**EPC STORMWATER REVIEW COMMENTS  
 IN ORANGE BOXES WITH BLACK TEXT**

## EL PASO COUNTY STORMWATER MANAGEMENT PLAN CHECKLIST

EPC Project Number: SP245

SHEET 4 OF 9

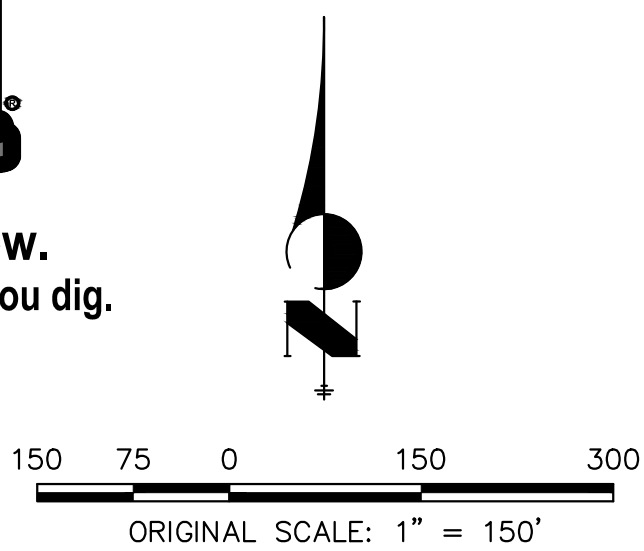
Applicant	EPC
17	SWMP Map to include: <span style="border: 1px solid black; padding: 2px;">See GEC Plan Comments</span>		
17a	construction site boundaries		
17b	flow arrows to depict stormwater flow directions		
17c	all areas of disturbance		
17d	areas of cut and fill		
17e	areas used for storage of building materials, soils (stockpiles) or wastes		
17f	location of any dedicated asphalt / concrete batch plants		
17g	location of all structural control measures		
17h	location of all non-structural control measures		
17i	springs, streams, wetlands and other surface waters, including areas that require maintenance of pre-existing vegetation within 50 feet of a receiving water		
18	Narrative description of all structural control measures to be used. Modifications to EPC standard control measures must meet or exceed County-approved details		Y
19	Description of all non-structural control measures to be used including seeding, mulching, protection of existing vegetation, site watering, sod placement, etc.		Y
